**RE: Goodwill at 270 98th St NW
Erosion and Sediment Control Plan
Engineer's Stamp Date 9/13/24 (K09E048E)**

Based on the information in your submittal received on 9/14/24, the ESC plan cannot be approved until the following comments have been addressed.

| Sheet: EROSION CONTROL PLAN |                 |

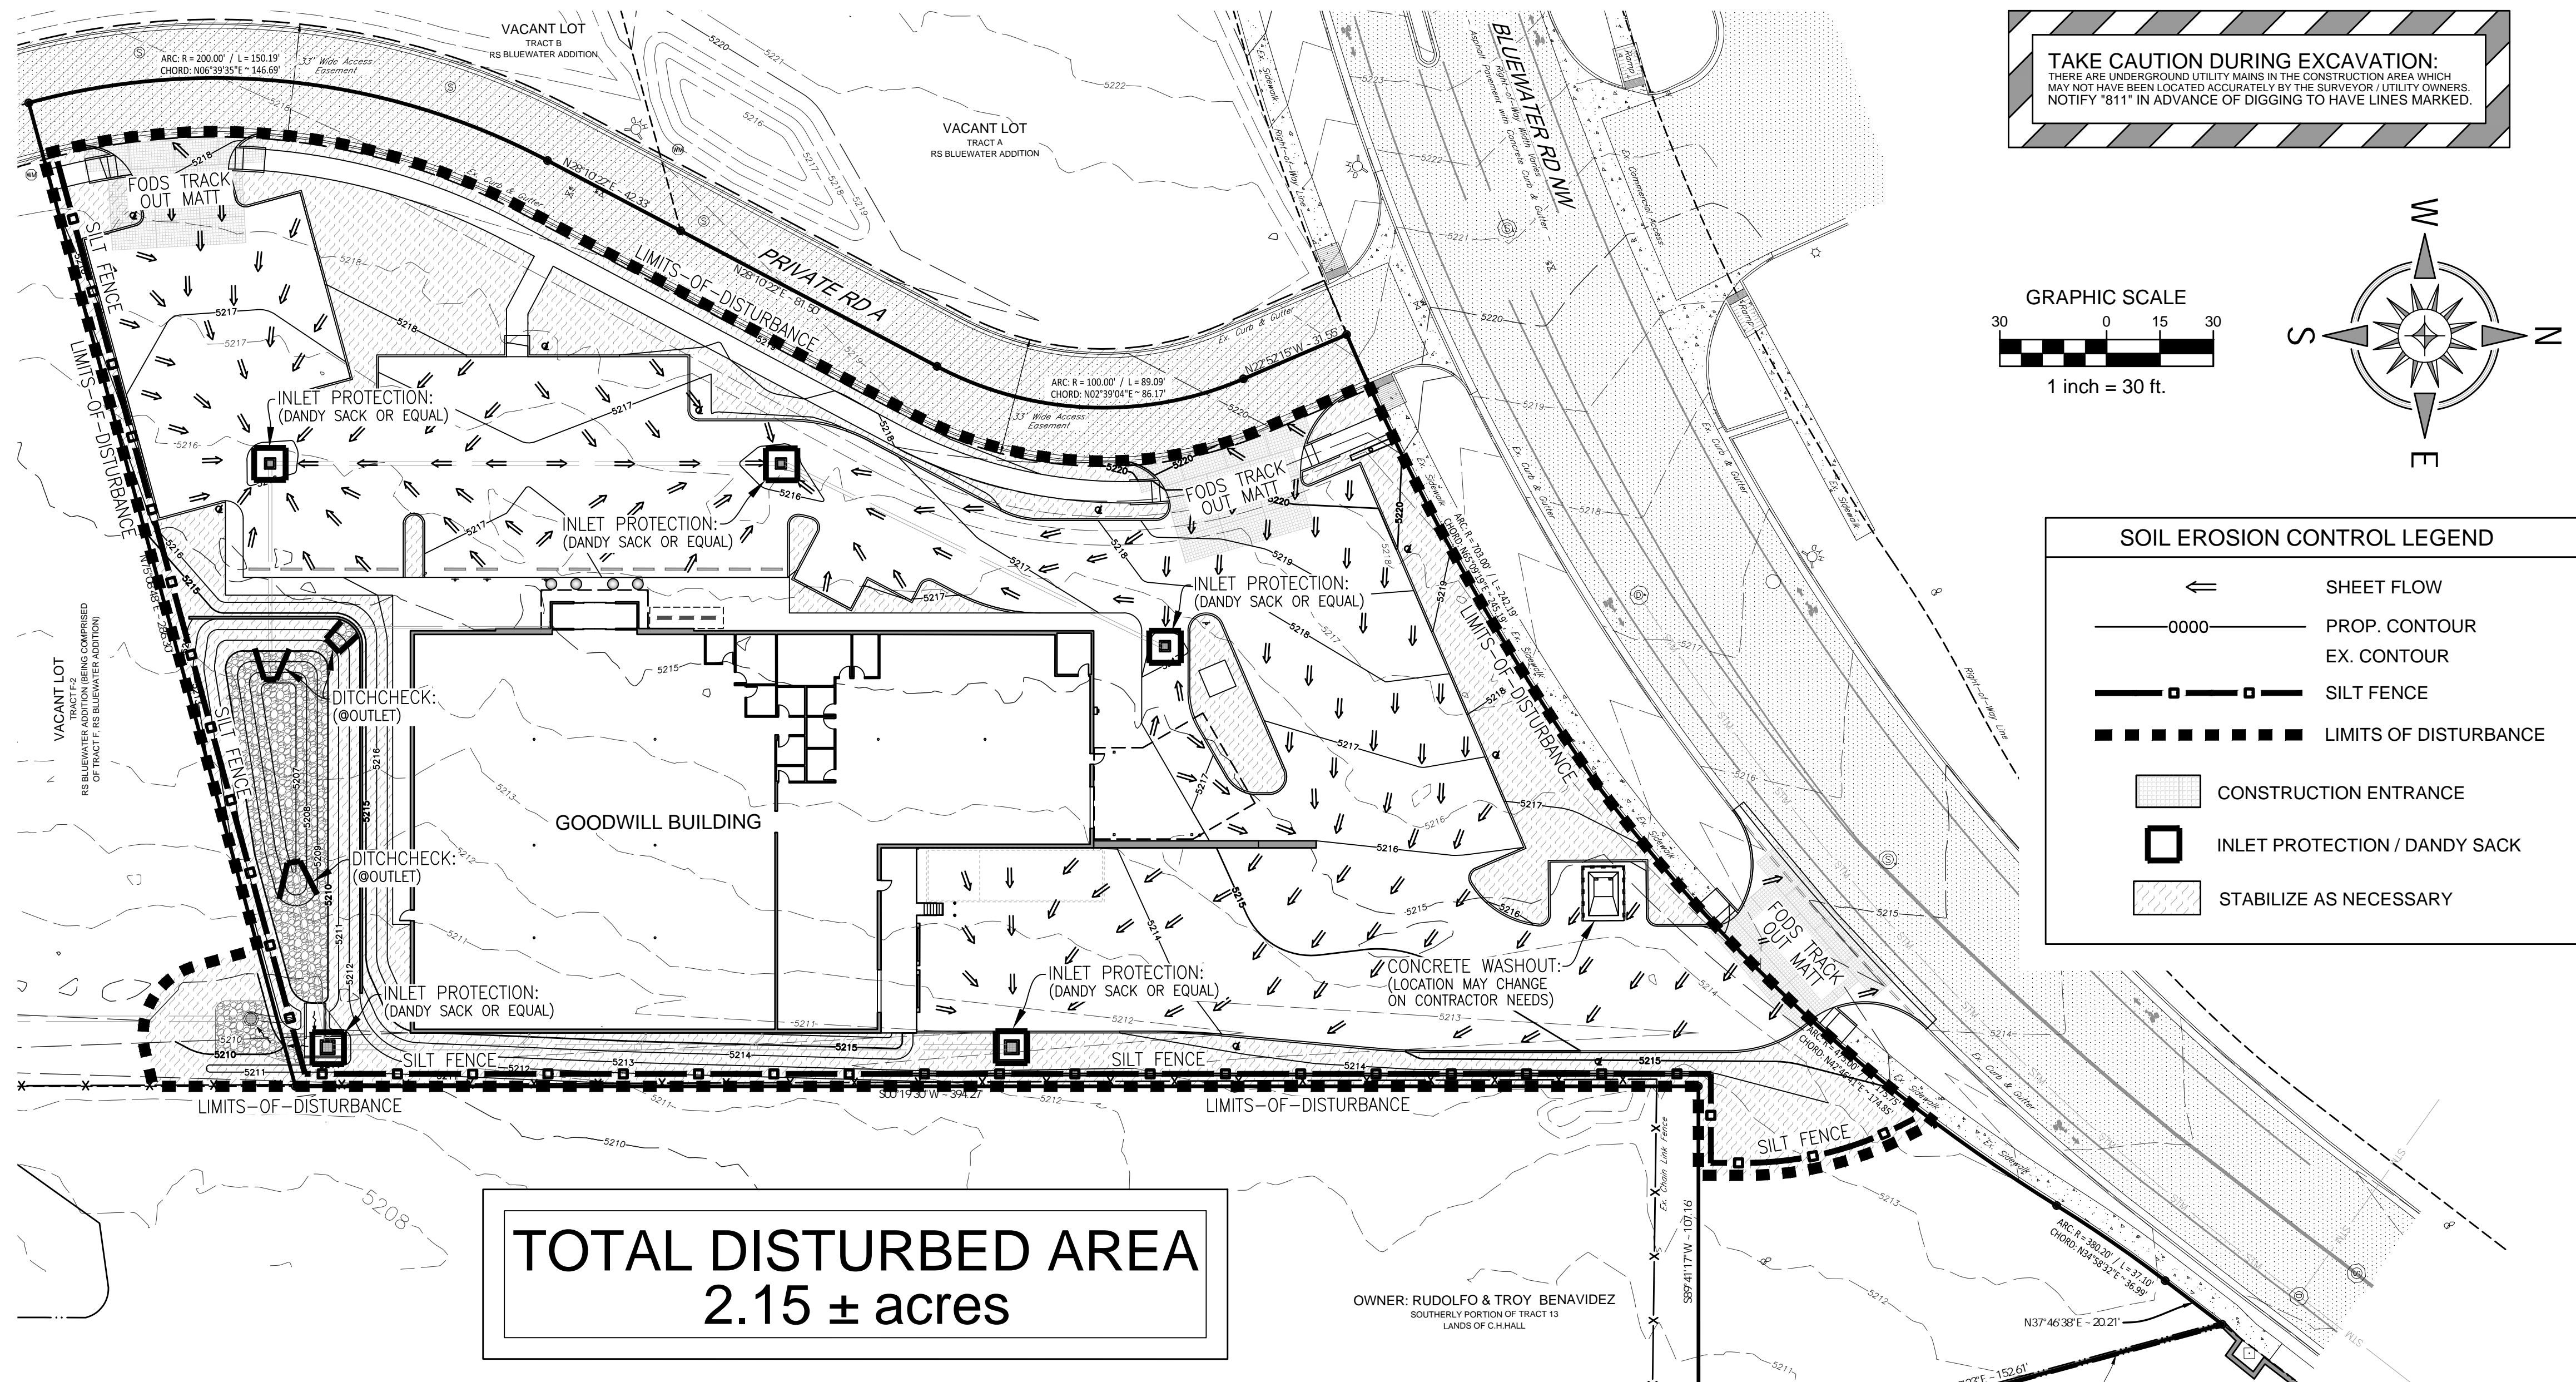
1. The ESC Plan can't be approved until after Hydrology approves the G&D Plan for each specific purpose, Site Plan, Grading, Building Permit, and Work Order. The only purpose Hydrology has approved so far is Site Plan. The existing contours along the south boundary of this site do not accurately show the prior grading on this lot by the Avalon Subdivision development. The existing and proposed grades must be accurately shown on the ESC Plan and agree with the Grading Plan approved by Hydrology per CGP7.2.4.b.ii.

3. The property owner's name, "GW Bluewater Development, LLC," on the ESC Plan and on the SWQ Information sheet does not agree with the available Bernalillo County records showing that "Goodwill Industries of New Mexico," a nonprofit corporation, is the property owner. The property owner's NOI is required by City Ordinance § 14-5-2-11. Property rights may have changed hands recently, if so, please provide documentation in the form of a recorded deed. The accurate name and contact information for the entity controlling the property rights is required on the Information Sheet, the NPDES documentation, the SWPPP, and the ESC Plan.

6. This site's only allowed stormwater discharge location is concentrated flow from the southeast corner. Silt Fence (SF) isn't adequate for concentrated flow, so you must provide diversion berms/swales (DV) along the low edges of the site to direct stormwater into a Sediment Basin (SB) or Sediment Trap (ST) per CGP 2.2.12 in addition to the SF.

- a. Design the basin or impoundment to provide storage for either:

- i. The calculated volume of runoff from a 2-year, 24-hour storm or
 - ii. 3,600 cubic feet per acre drained.
 - b. Utilize outlet structures that withdraw water from the surface of the sediment basin or similar impoundment unless infeasible.

- c. Use erosion controls and velocity dissipation devices to prevent erosion at inlets and outlets.
 - d. Remove accumulated sediment to maintain at least one-half of the design capacity and conduct all other appropriate maintenance to ensure the basin or impoundment remains in effective operating condition.

- Include the following information for the SB or ST in your resubmittal.
- e. Specific location of the basin, including dimensions.
 - f. Plan view of the storage basin and emergency spillway, showing existing and proposed contours.

- g. Add a bold note at the pond saying, "the pond may not be removed until the rest of the construction is complete and the site is stabilized."
 - h. Cross section of dam, principal spillway, emergency spillway, and profile of emergency spillway with elevation specifications for each.

- i. Hydraulic capacity calculations and construction specifications for the principal pipe outlets.
 - j. Runoff calculations, 24-hr volume, and peak flow rate for 2-year, 10-year, and 100-year frequency storms assuming the densest impervious cover that will occur during construction.

- k. Hydraulic capacity calculations and construction specifications for the emergency spillway if the primary outlet won't pass the 100-year flow.
 - l. Storage computations

Sheet: EROSION CONTROL NOTES & DETAILS

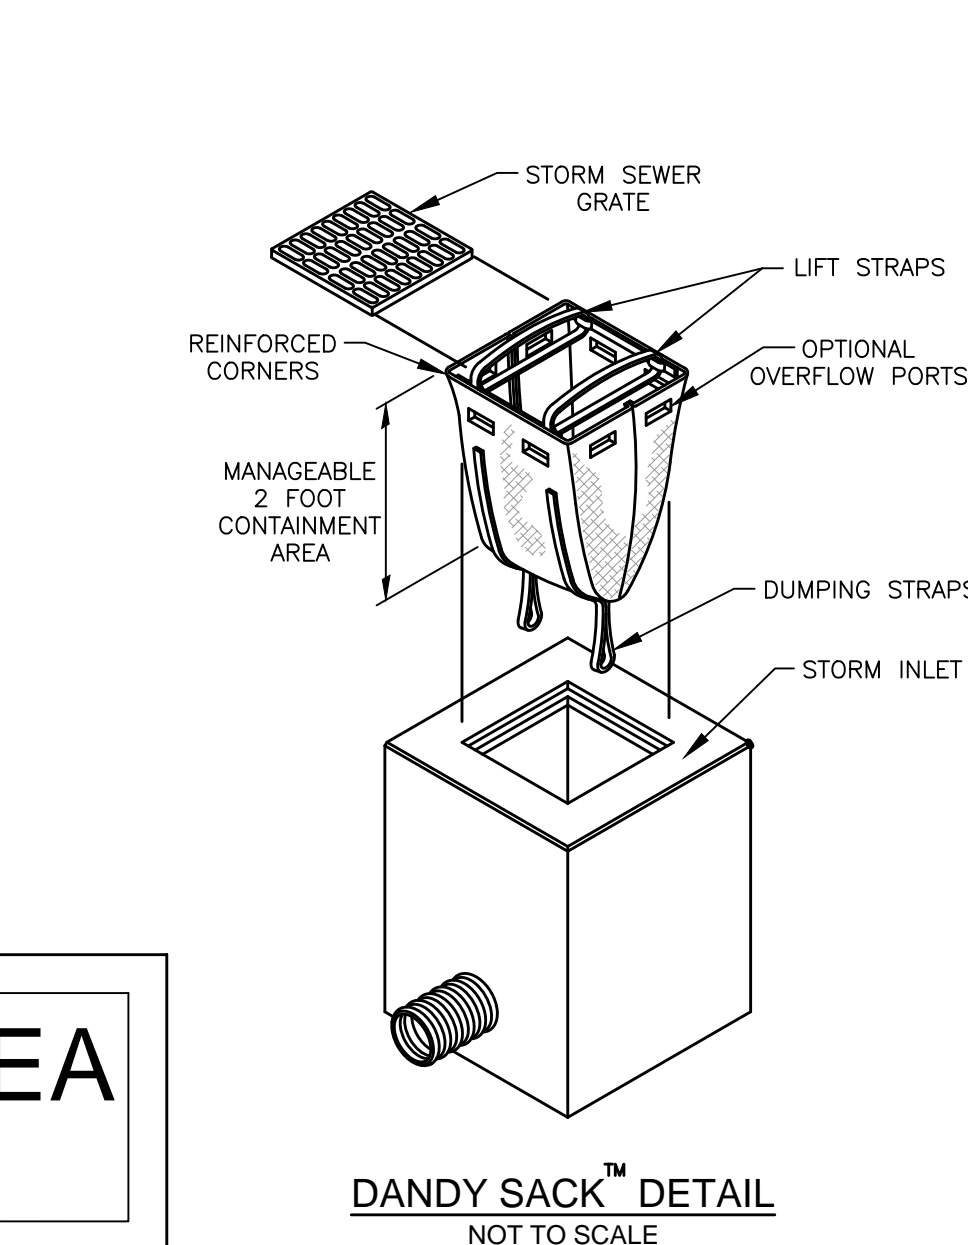
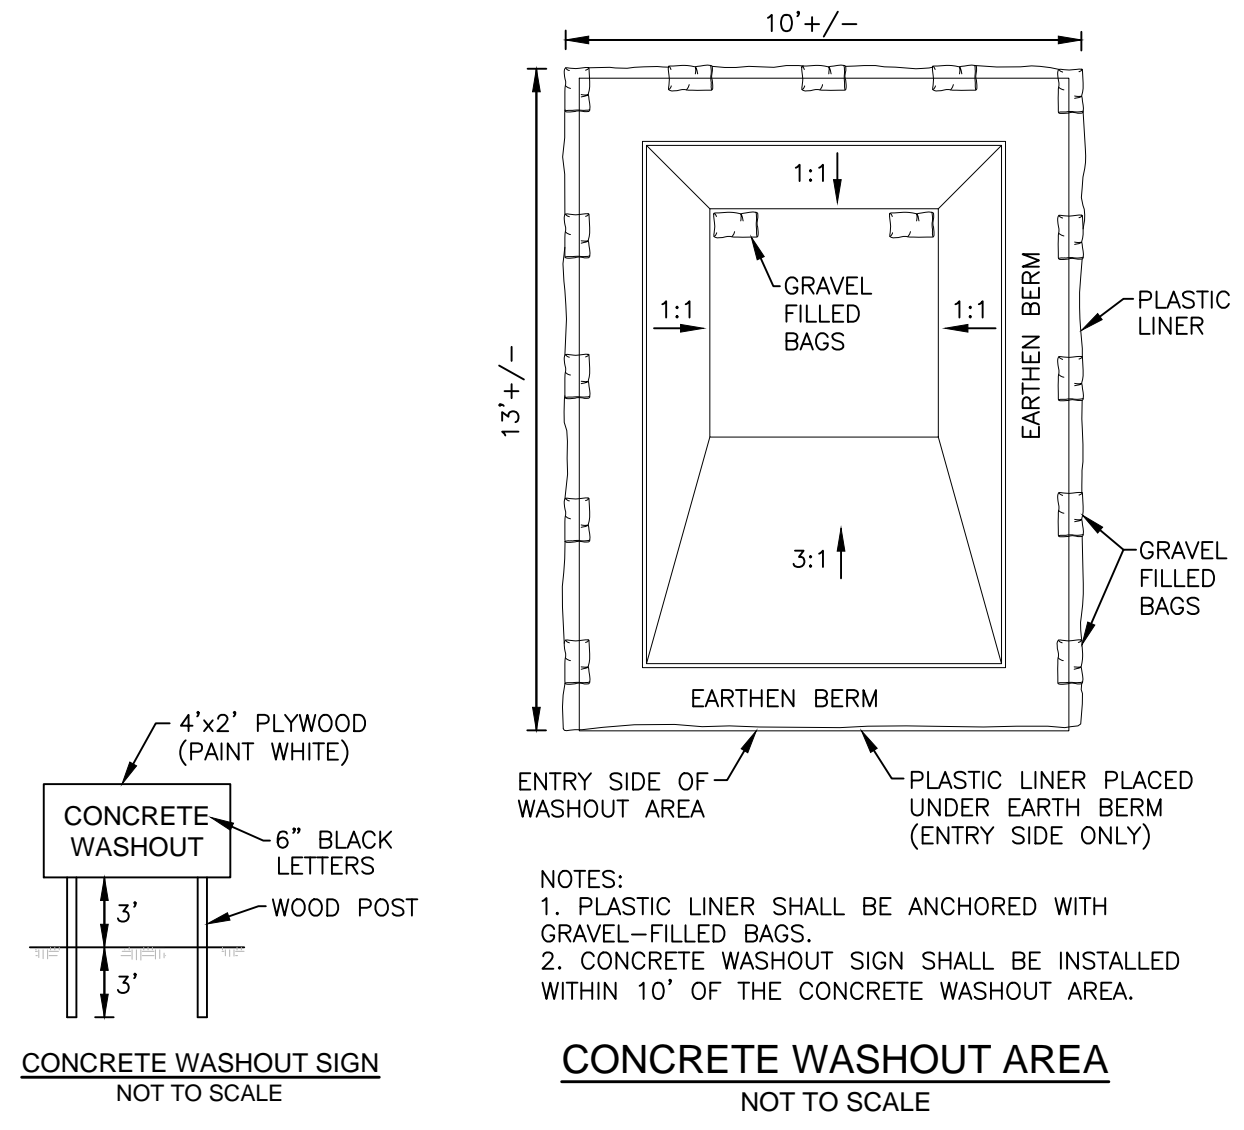
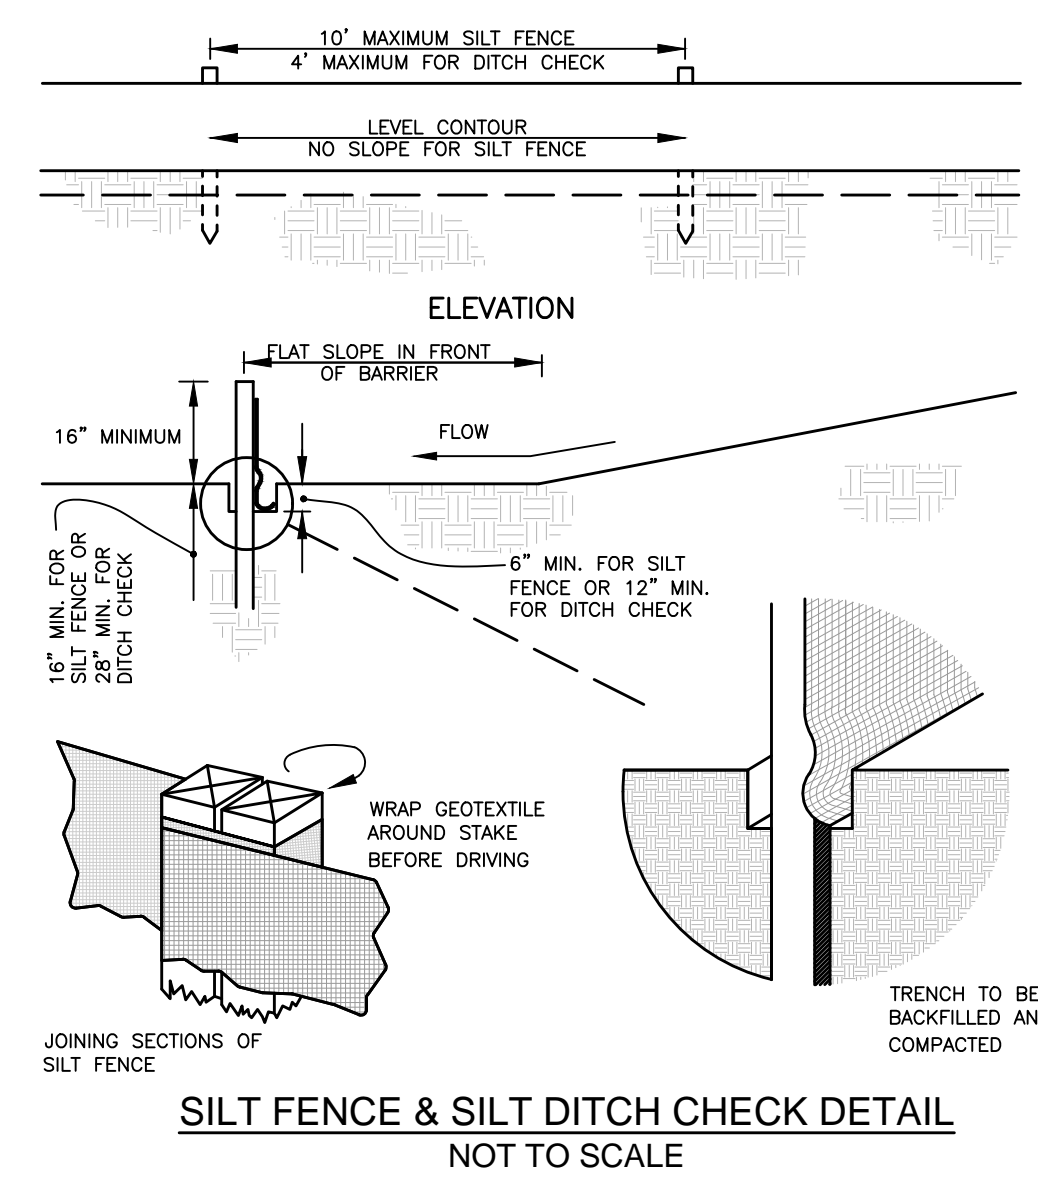
- m. Sediment volume required (& calculations)
 - n. Sediment volume available, cleanout elevation, and depth below the primary outlet.
7. Construction details and specifications for DV, SB, and ST are missing and must be added to the Detail sheet per CGP 9.6.1.c.i.
